November 19, 2021

RE: Village at Waterview North - EGP214

The Development Drainage Preliminary Drainage Report dated July 15, 2021 and supporting drainage documents has been reviewed by a CDOT Hydraulics Engineer and their comments are:

Z:\0001-Dakota Springs\02-Waterview Partners\19-05 Waterview North Site\CAD\Plansheets\Pre-Dev Grading\WVN - pdg\_grades SWMP.dwg

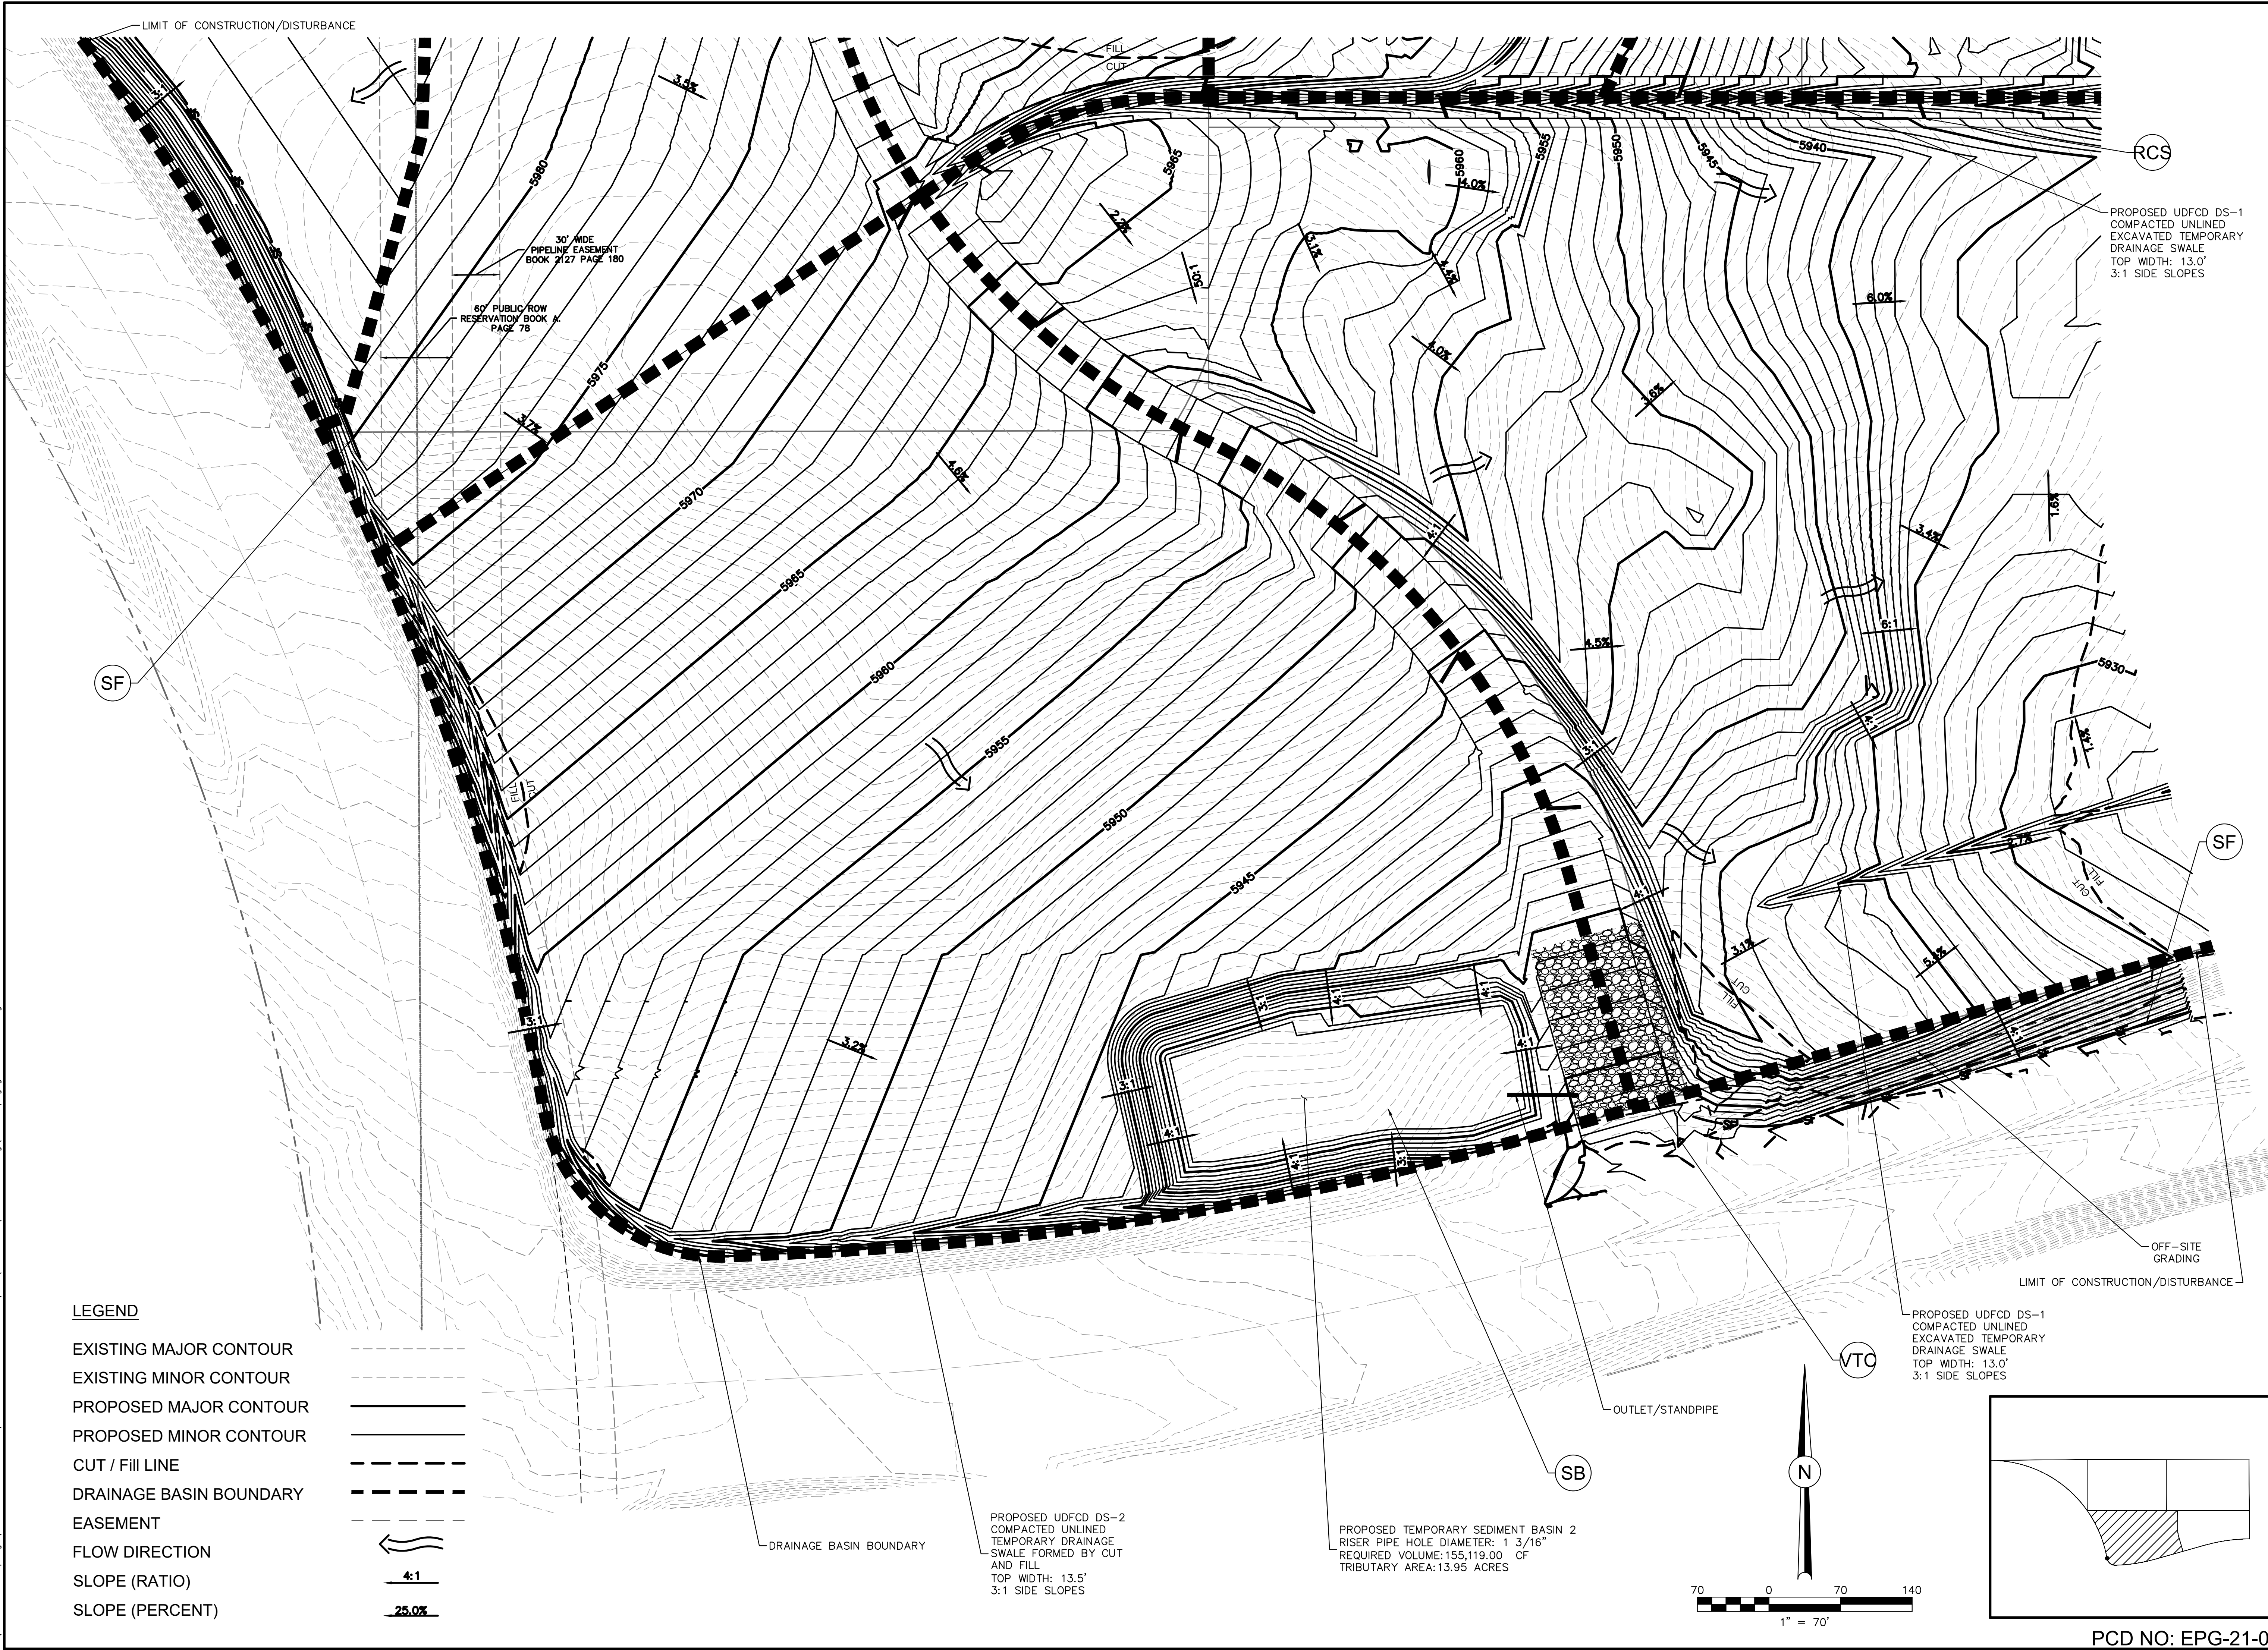
- On the grading and SWMP plans, the existing contours don't have elevations.
- There appears to be a pond/permanent sediment basin in the grading file in the NW corner, but it is not discussed in the drainage report.

GRADING PLAN (1 OF 5)

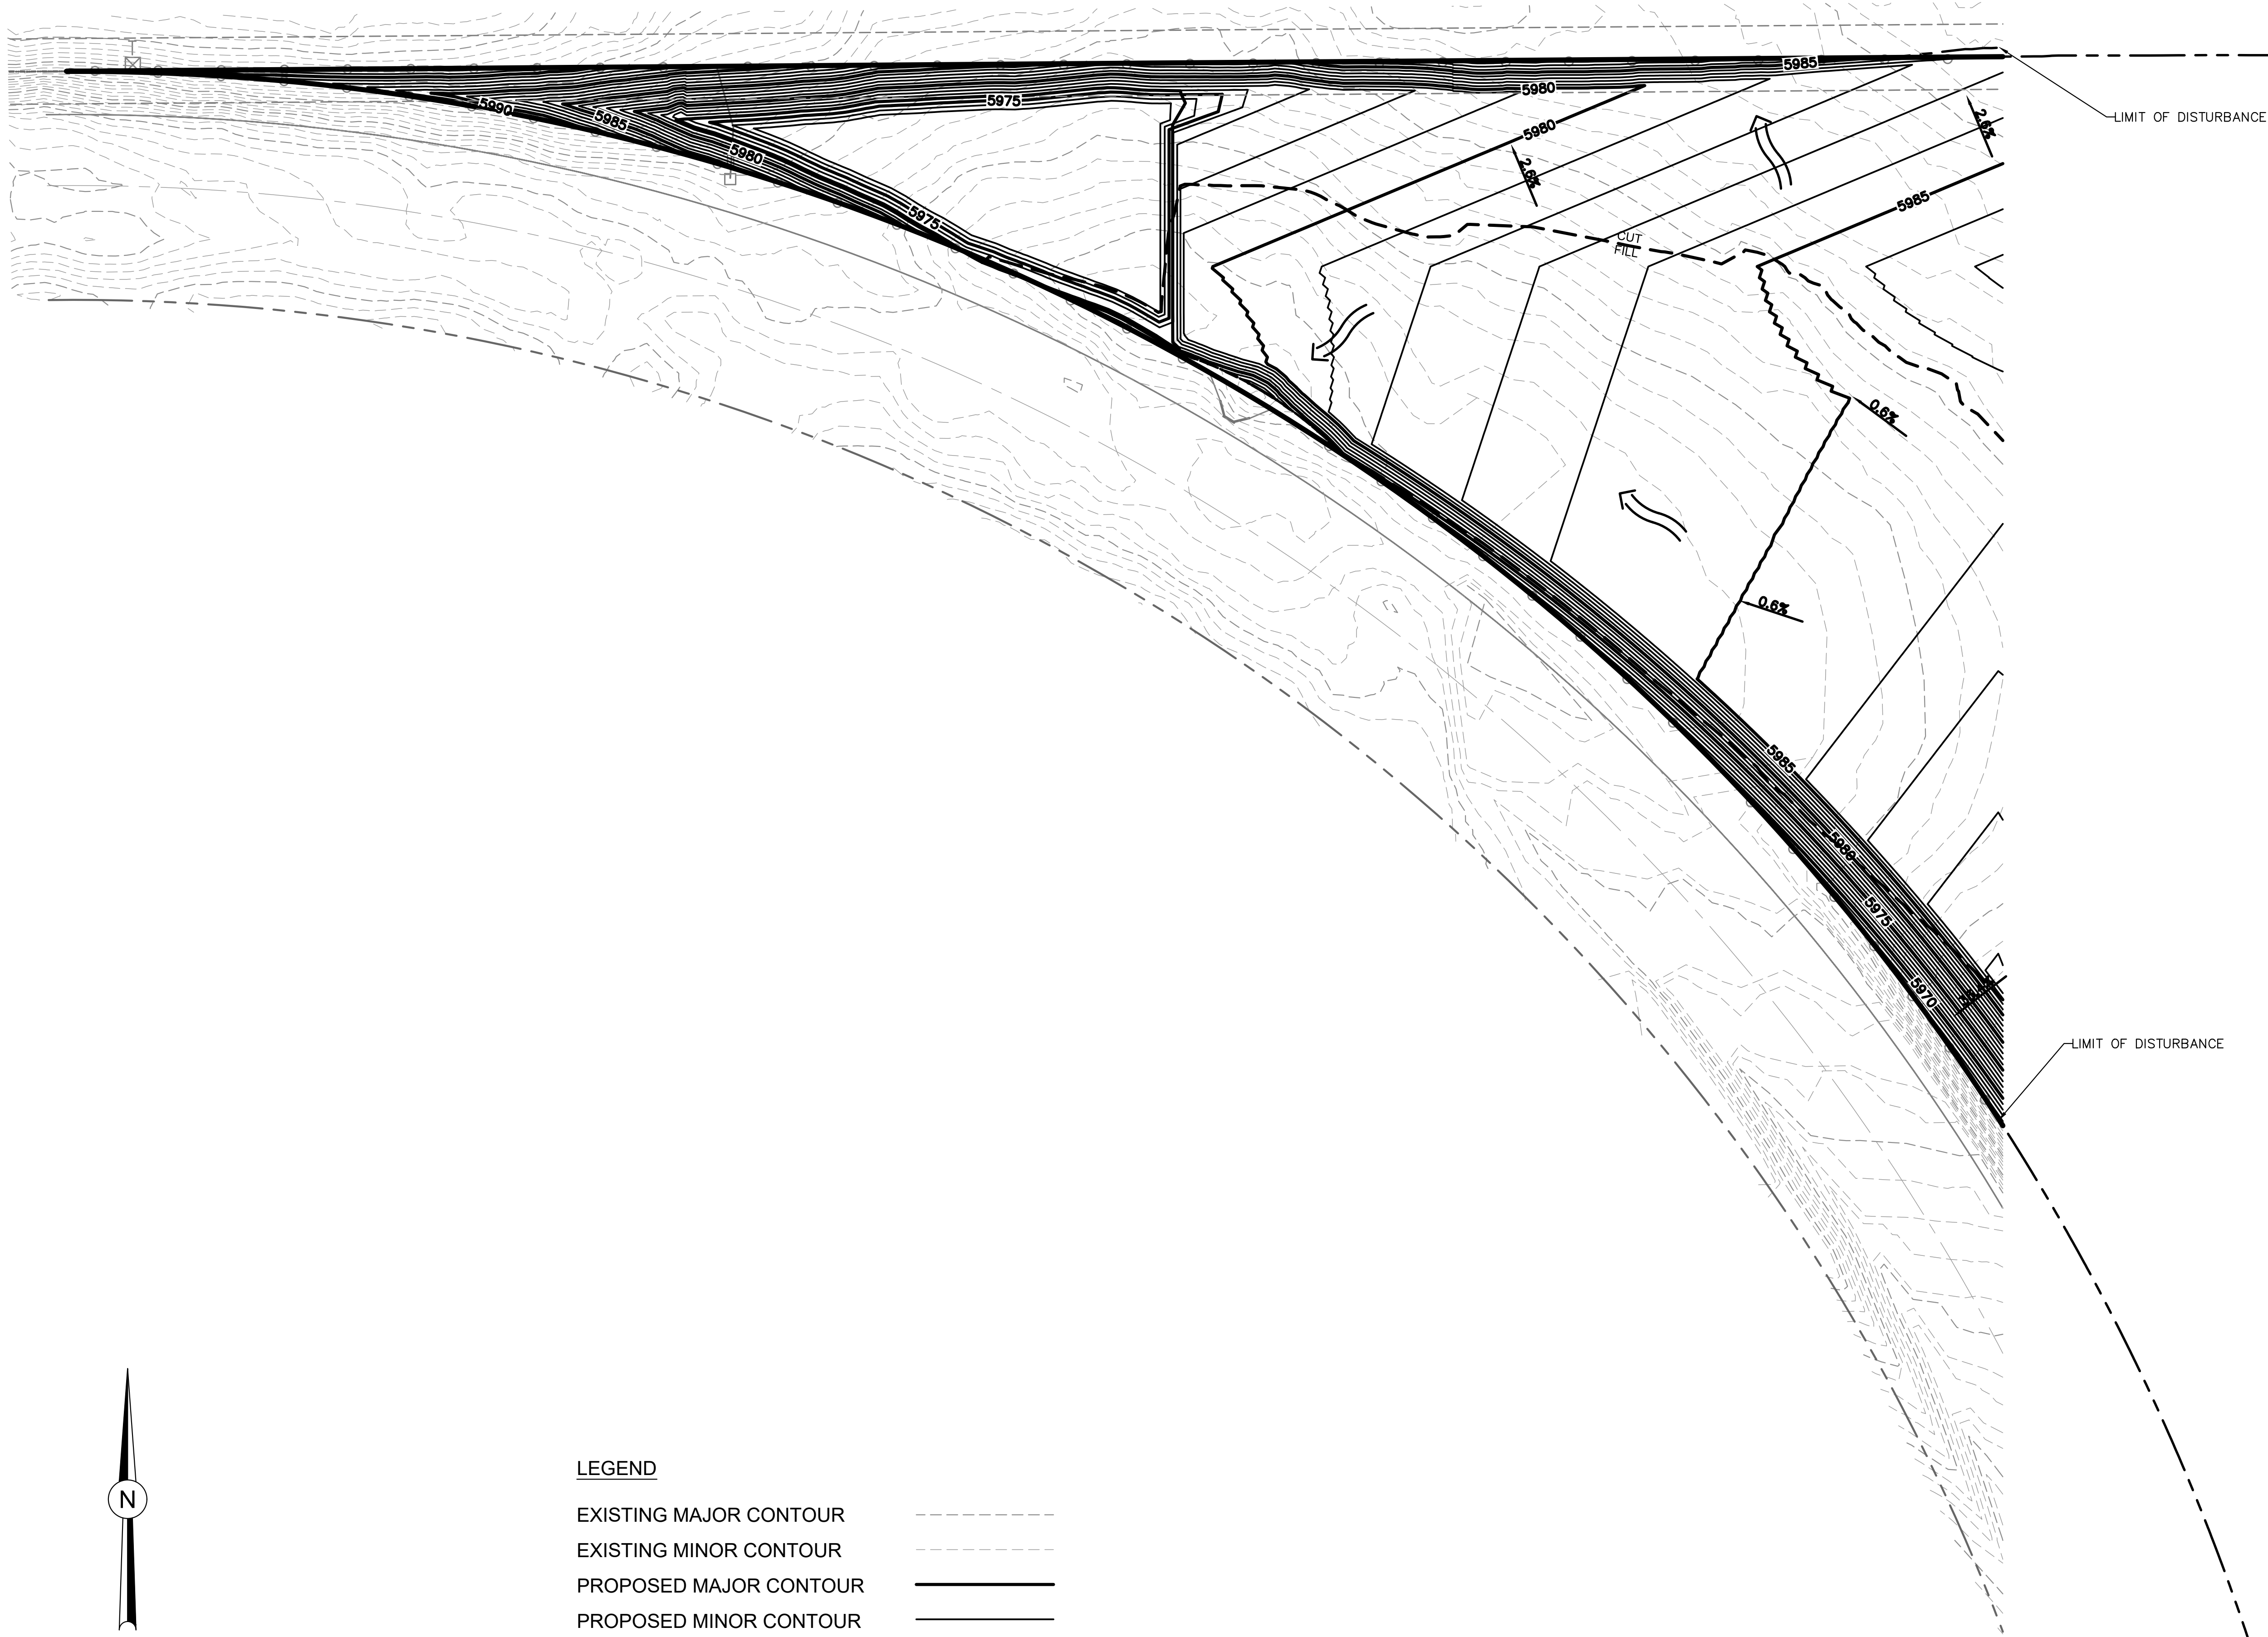
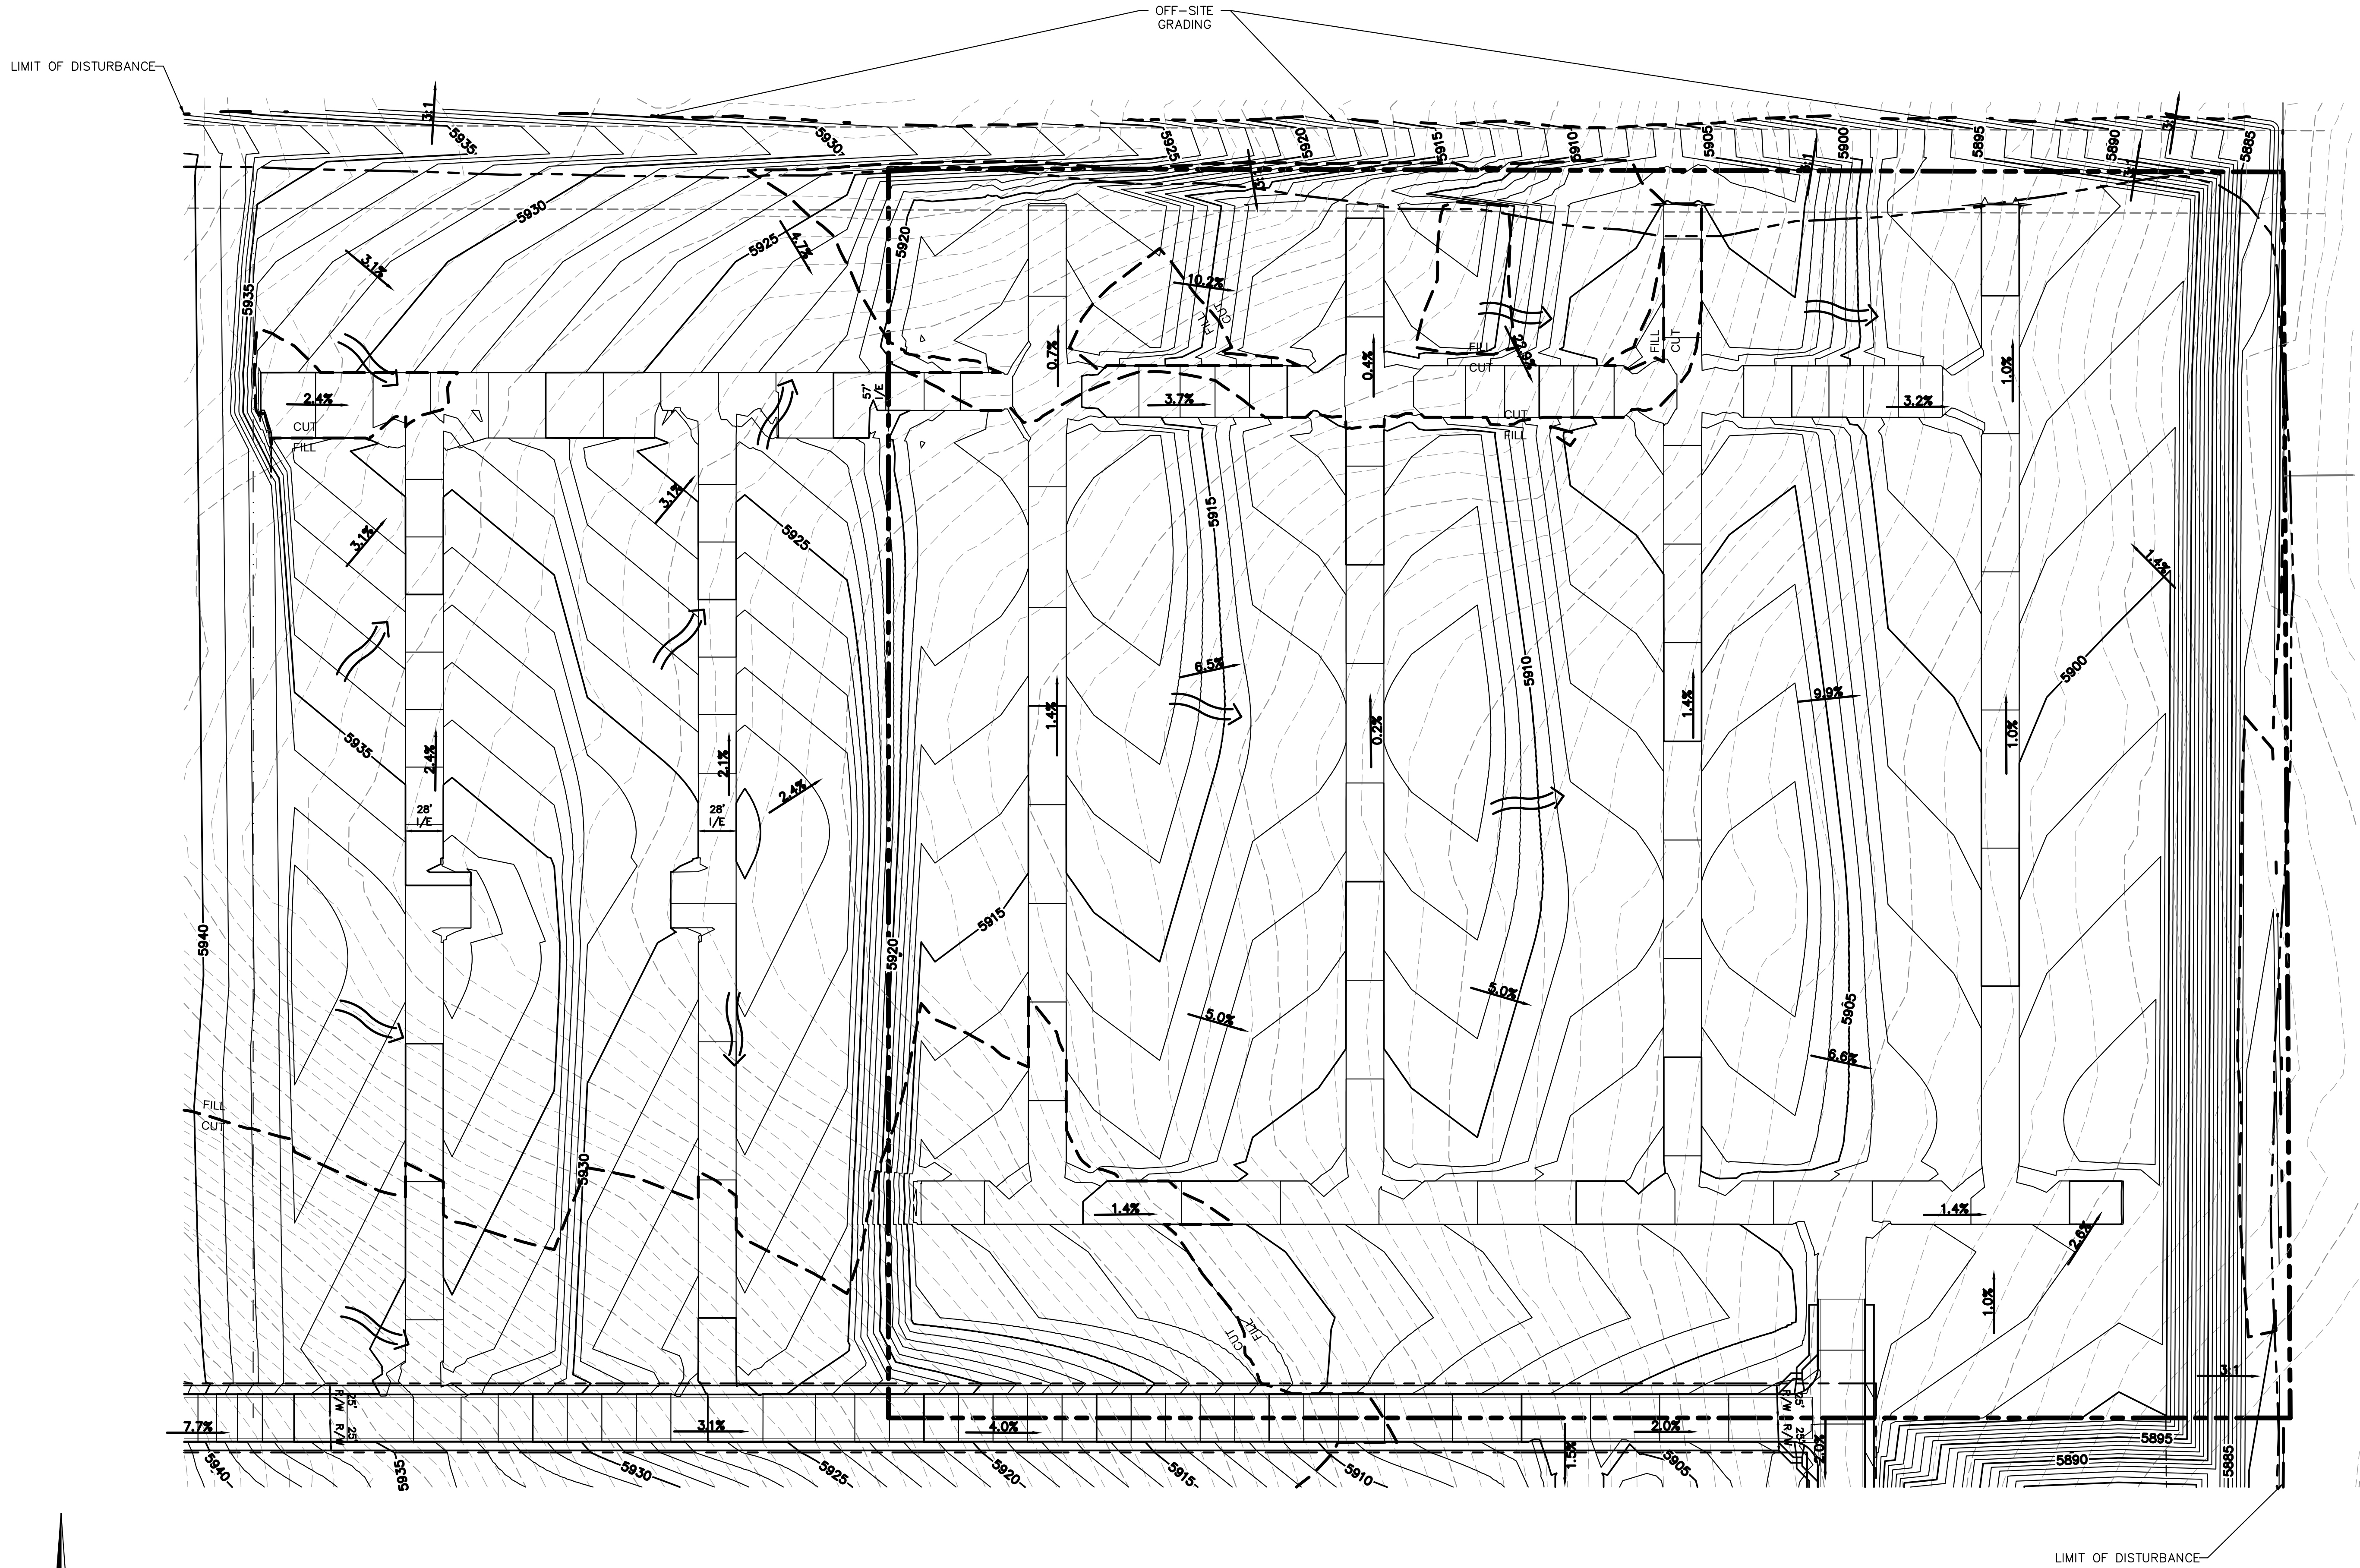
- The pond grading appears to show an overflow spillway that would discharge onto CDOT ROW. This needs to have a maintenance agreement associated with it.
- There is no storm infrastructure shown on the plans, it cannot be determined if all flows leave the site away from Powers or if there is discharge into CDOT ROW.
- There is an existing CBC under Powers that is not discussed in the report. It cannot be determined the culvert is adequately sized in the existing, and if flows from the planned development will impact CBC capacity.
